Application for non-material amendment to Planning Permission 2024/62/91998/W

“Erection of special educational needs and disabilities school (use class F1), comprising educational buildings, roof mounted photo-voltaic panels, sensory garden spaces, multi-use games areas, landscaping, hardstanding areas, carparking, access with secure fencing and associated ancillary development”

Specifically, this application proposes non material amendment to drawings referenced in condition 2 (Plans and Specifications Schedule), condition 20 (lighting) and Condition 22 (Drainage).

TITLE
**GA ELEVATIONS
COURTYARD**

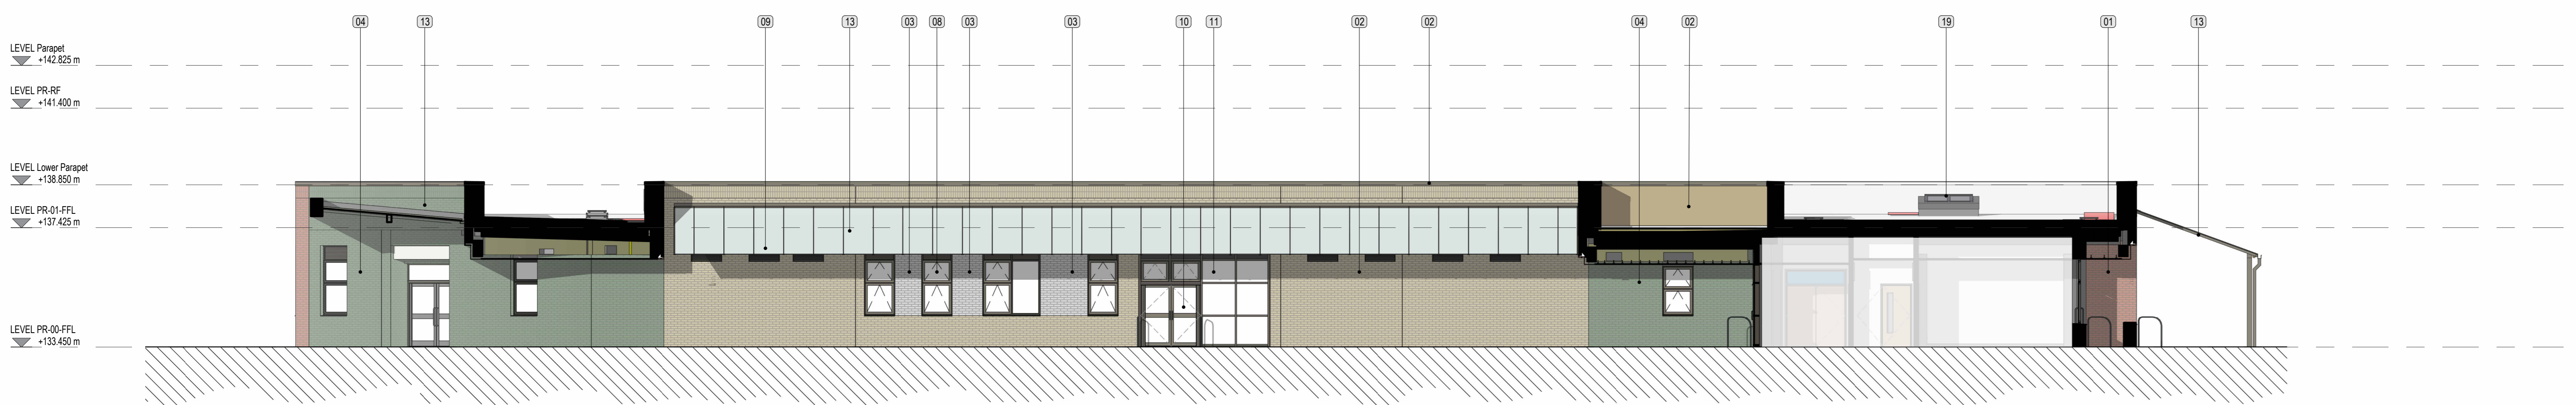
- General update to the windows designs
 - Head of windows and openings lowered by 150mm throughout.
 - Base of all windows lifted to +1050mm throughout (except wing), removing low level spandrel panel to some windows.
 - Removal of 'look-alike windows' within courtyard to maintain only louvre at head.
- Removal of glazed canopy and bridging brickwork parapet.
- Removal of sections of render and replacement with glazed brick in some location.
- Changed layout to group room windows on western elevation and removal of external downpipes
- Reduced depth of recesses to some entrance doors.

In addition, a non-material amendment to the building layout is proposed. A 15m² extension is proposed on the ground floor into the courtyard area.

TITLE
EXTERNAL LIGHTING SHEET 1 OF 2

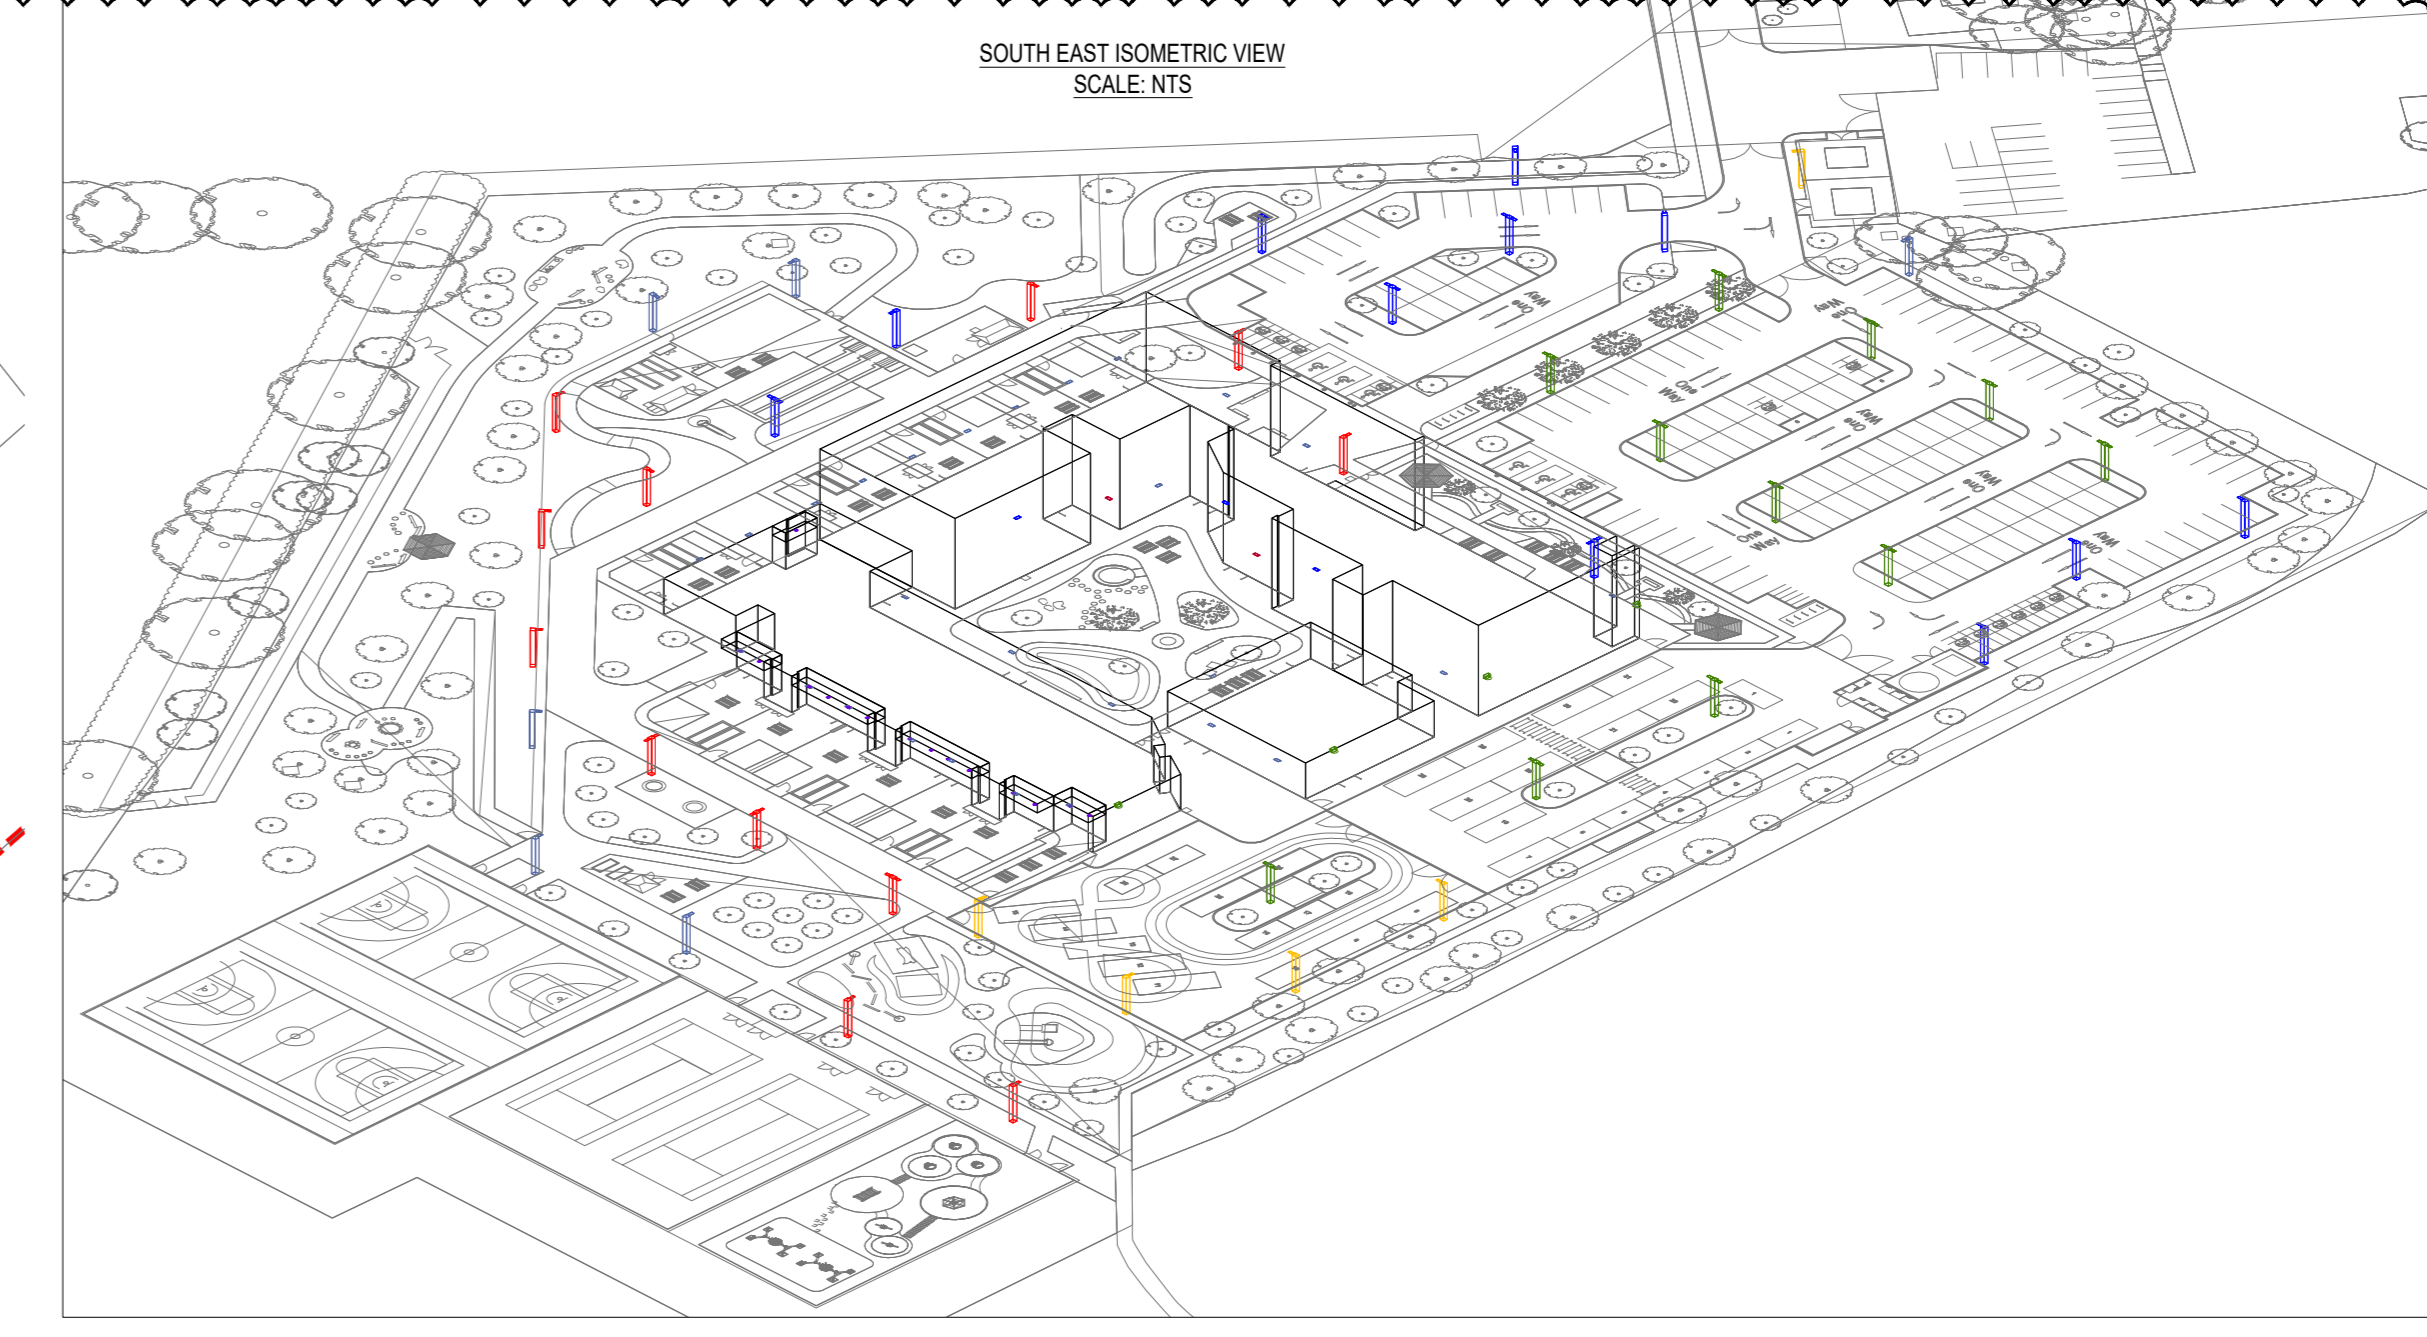
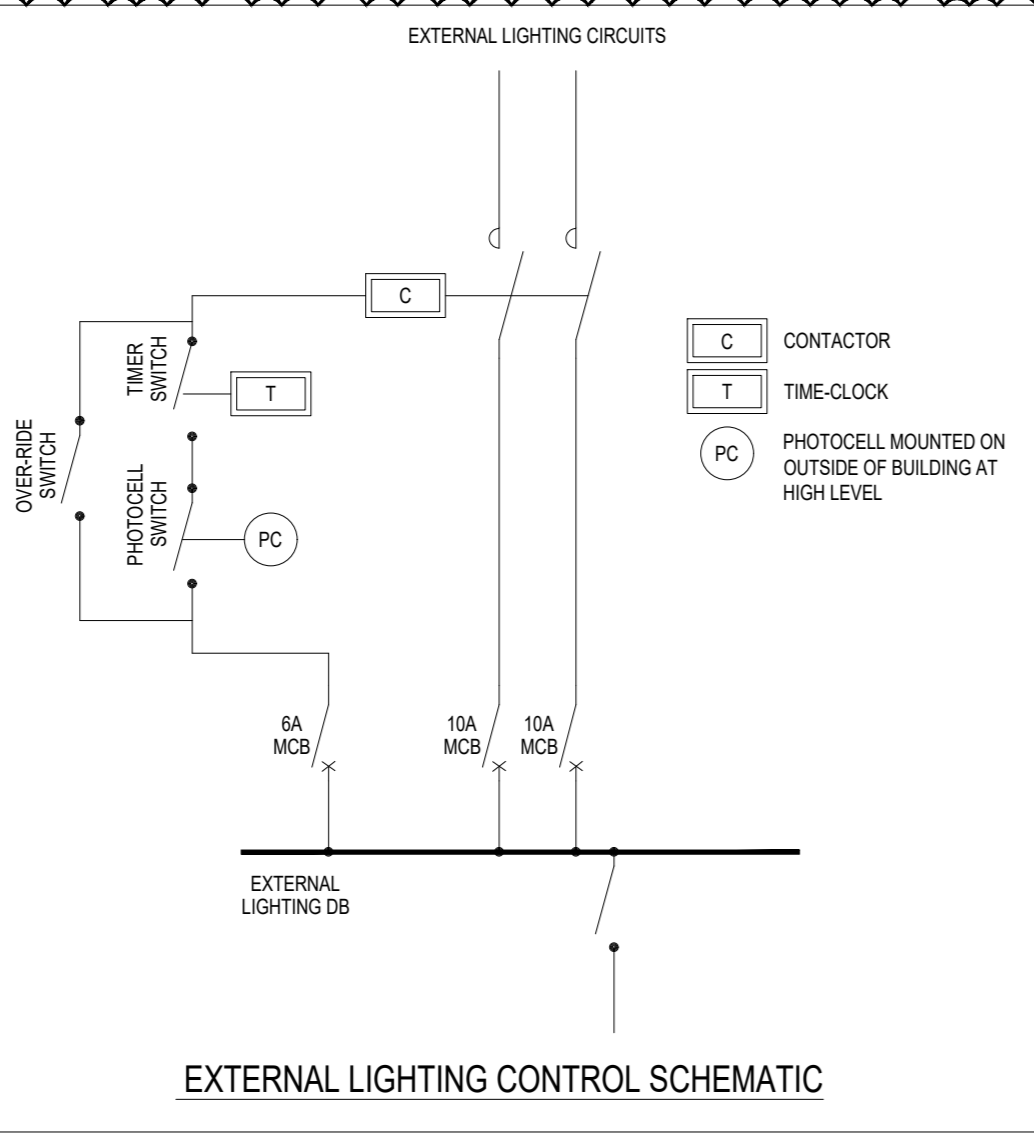
Whilst the specification of the lighting remains unchanged, an updated lighting drawing has been prepared to reflect non material changes following Stage 4 Design.

*“The external artificial lighting for the play area shown on hereby approved drawing nos. **NWSC-GAH-00-00-D-E-01101-External Lighting Sheet 1 of 2-S3-P03** & **NWSC-GAH-00-00-D-E-01102-External Lighting Sheet 2 of 2-S3-P03**, and any external lighting erected for the MUGAs, shall only be operated between -*
